Your Ref: OWPC20562
Our Ref: FG/169/18/HH 18-09-2018
Please ask for:
Zac Denton

Loft conversion , rear extension & garage extension.
11 Downview Road Ferring

Thank you for your internet representation made on 14th November 2018 which has been recorded as '**an objection**' with the comments as follows:

PROPOSED REAR ELEVATION

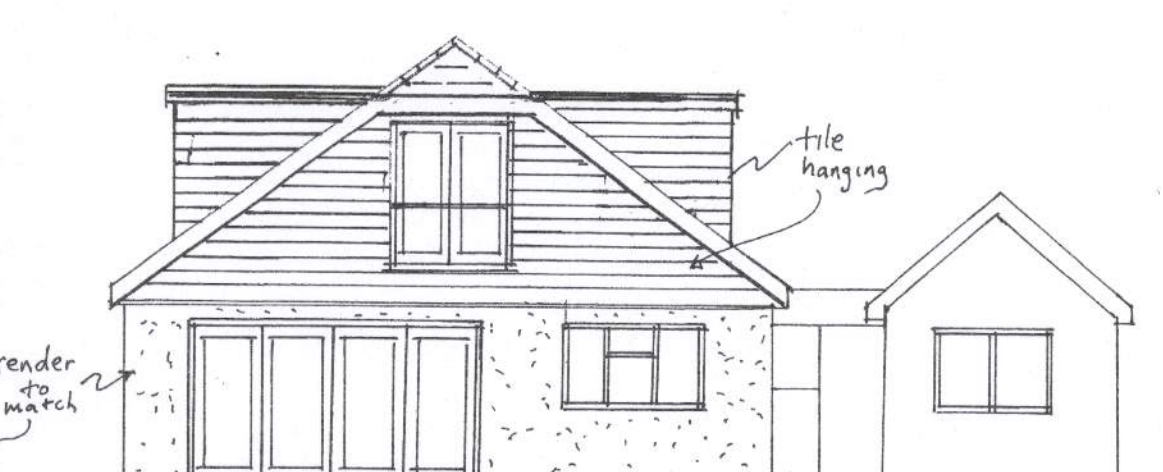
We support the application in principle with one objection. That is the rear elevation, first floor external double doors. The concern is that at some point it is likely that a balcony or raised platform will be added to provide outdoor access from these doors. This would provide a clear view into our garden and those of other neighbours. As such there would be a significant impact on our privacy and that of other neighbours. We would however support the replacement of these doors with a standard window.
